11 April 2022
Ref: W2635

Application reference FG/54/22/PL
Land rear of 1 Sea Drive Ferring BN12 5HD

1 No new dwelling. This application is in CIL Zone 4 and is CIL Liable as new dwelling.

Proposed Site Plan  
Scale 1:100 @ A1

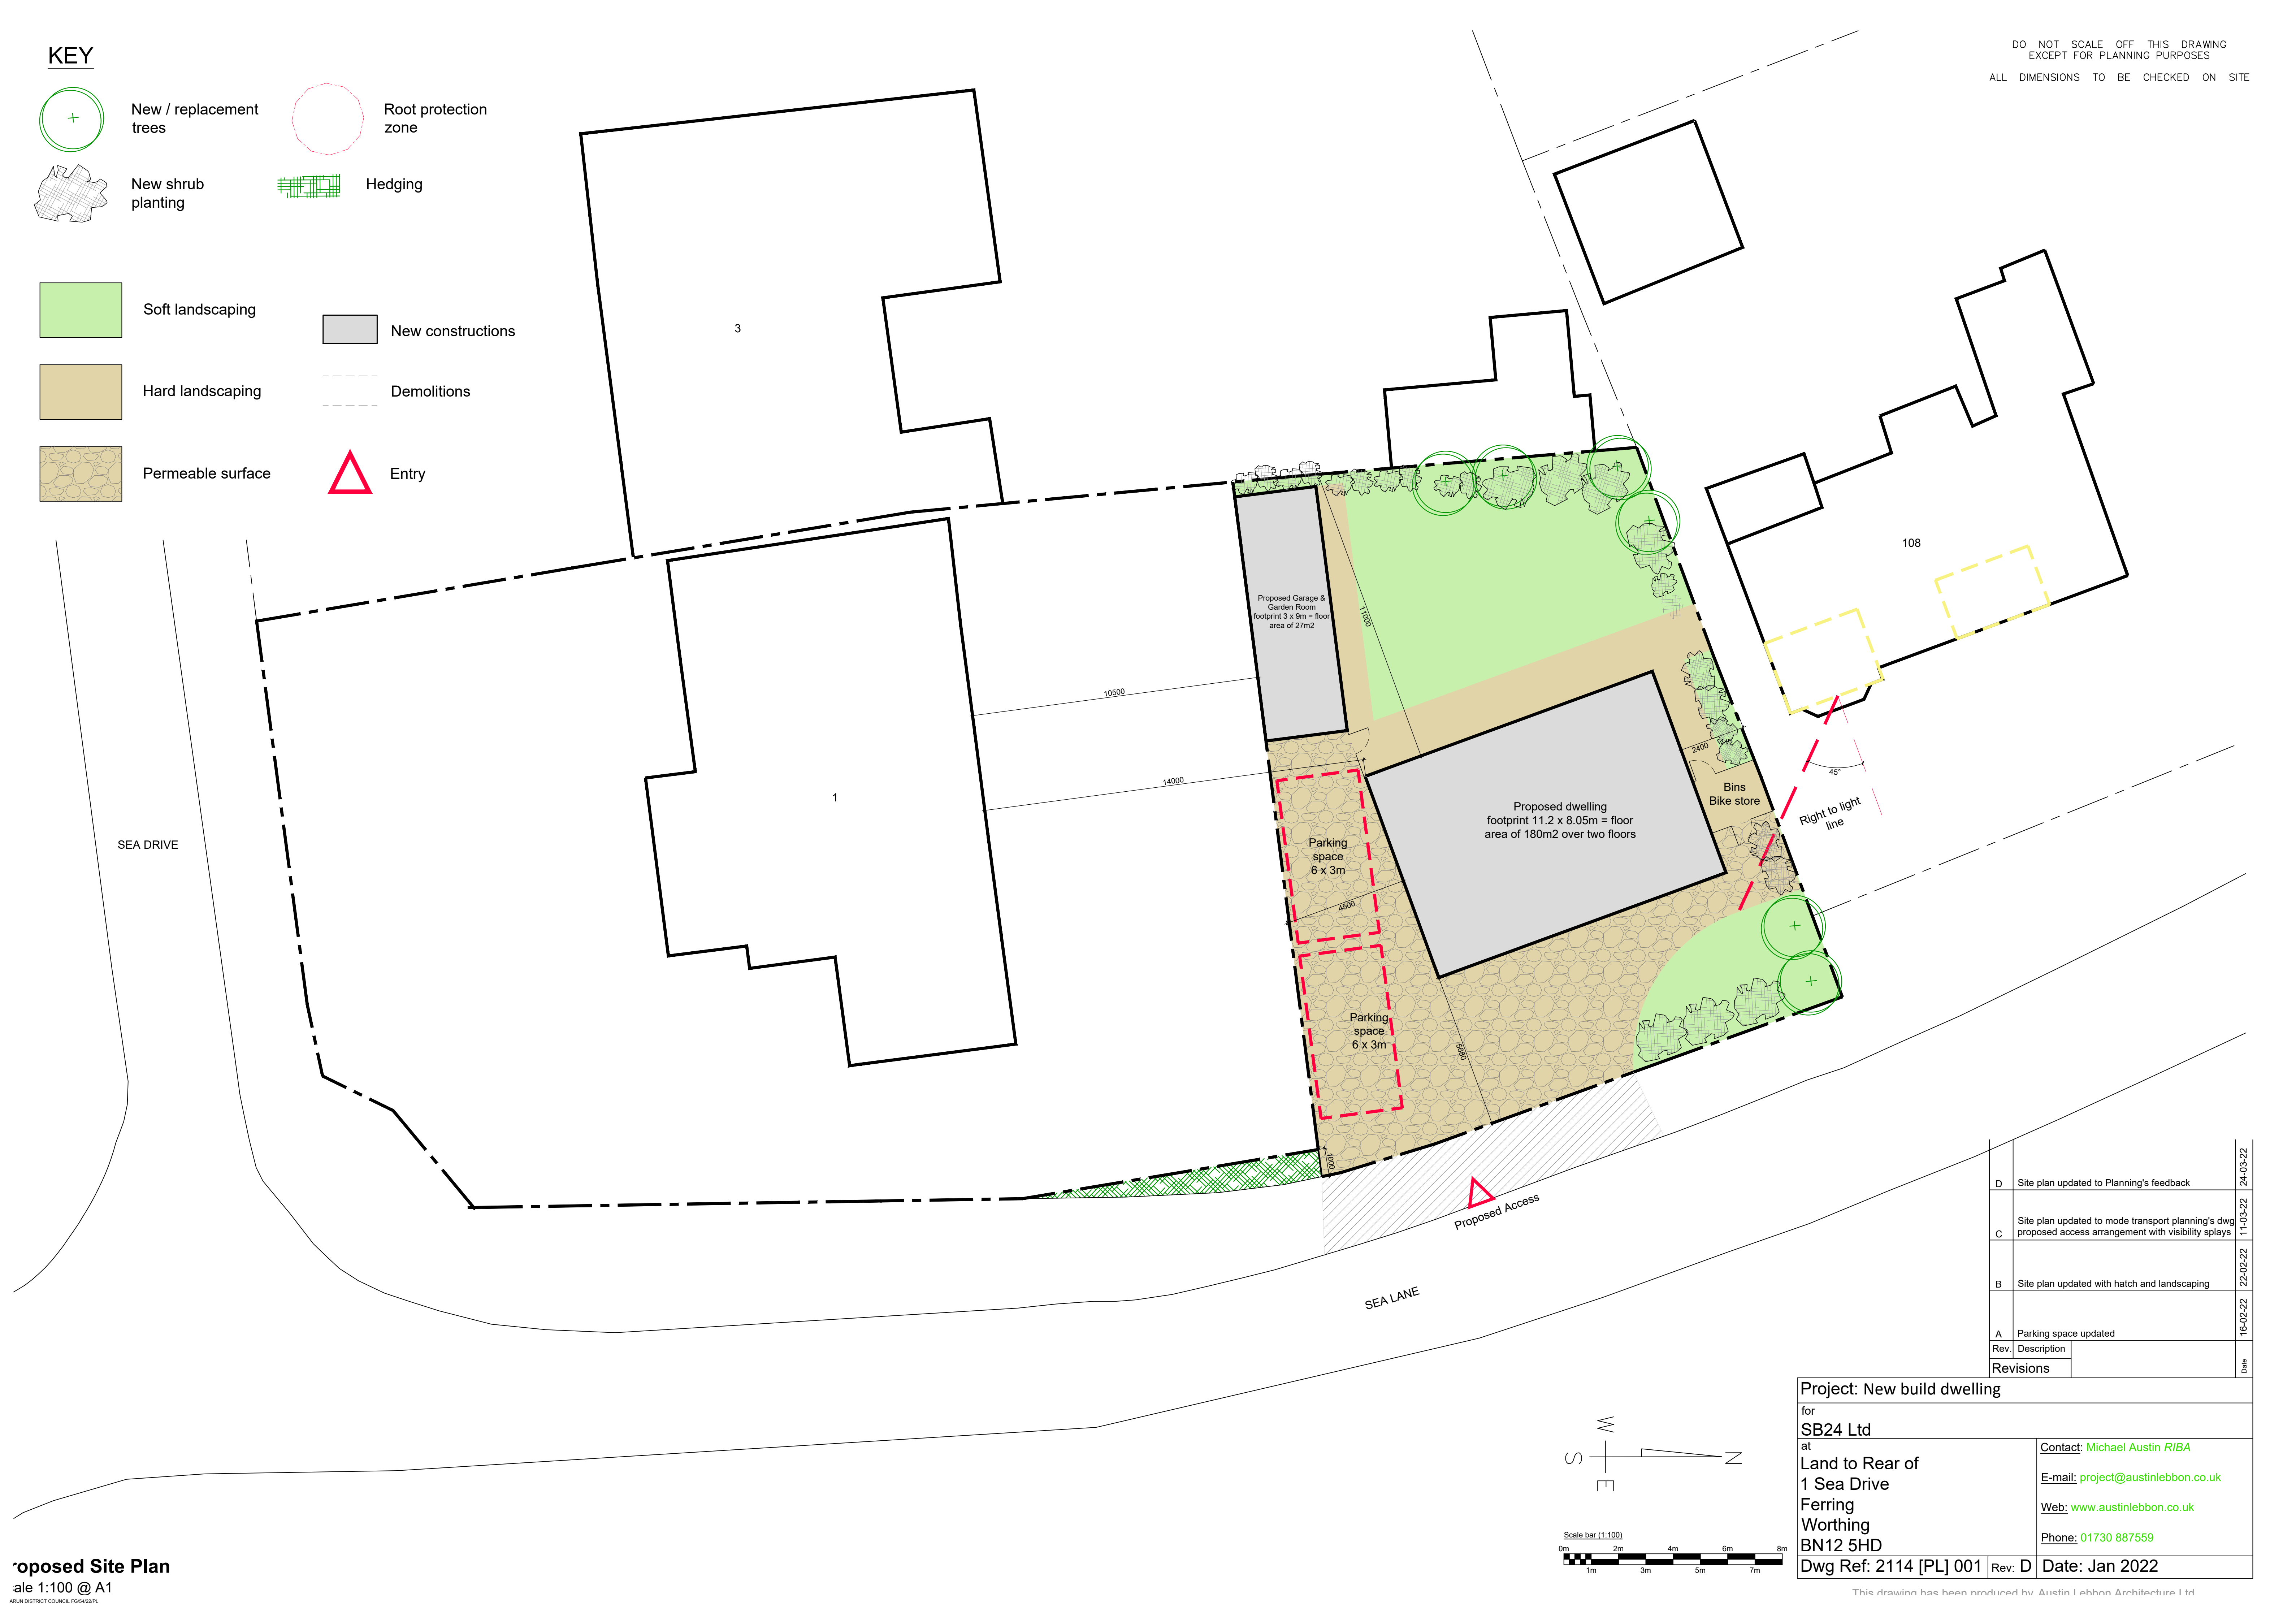
12. The proposed dwelling would only slightly impinge on the 14m guidance and would include an 11m deep rear garden, however this is only possible with the dwelling set significantly further forward (approximately 5.1m) than the established front building line on Sea Lane. The dwelling is also set within close proximity (2.4m) to the shared boundary with no. 108 Sea Lane.

- Use materials to match those used within the surrounding area
14. The proposed dwelling would be set 5.1m forward of the building line and the roof form would include a large full height gable to the front elevation and a pitched roof to the rear elevation. As a result, the bulk of the dwelling would be set significantly further forward than no. 108 and other dwellings to the north/south (see figures 1-3 below). The proposed dwelling would be set within close proximity to (4.1m) to southern flank wall with 108 Sea Drive and would appear cramped and overdeveloped within the street, which is comprised by dwellings set within spacious plots. The dwelling would therefore disrupt the rhythm and spacing within the street scene, as illustrated in the series of extracts from the submission shown below.

Figure 1 – Image adapted from application drawing: Proposed Site Plan (ref. 2114 [PL] 001 Rev: D) illustrating building line (source www.arun.gov.uk)

Proposed Urban Grain
Scale 1:500 @ A1

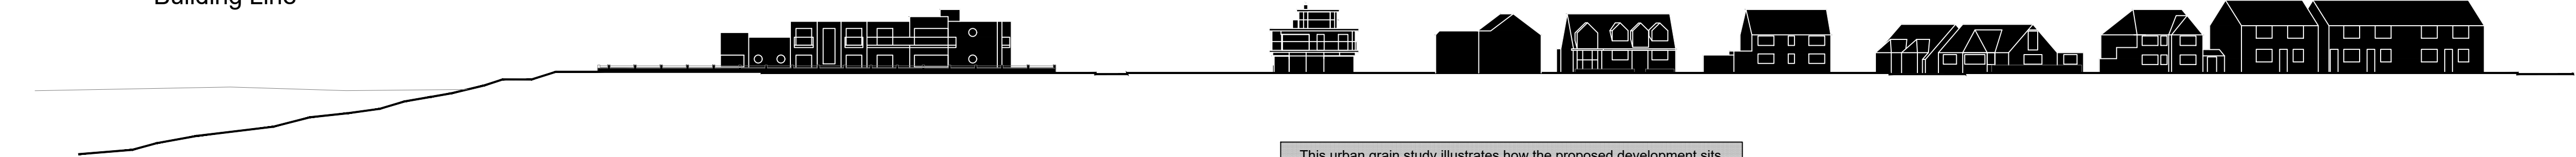
15. The existing/proposed Urban Grain plans submitted as part of the application are inaccurate as they significantly exaggerate the step forward of St Malo Court to the north of the site. In reality St Malo Court is set only marginally further forward than 102 Sea Lane, as shown below and overleaf.

Figure 5 – Image adapted from application drawing: 2114[PL]101 Rev A illustrating building line and incorrect position of St Malo Court (source www.arun.gov.uk)
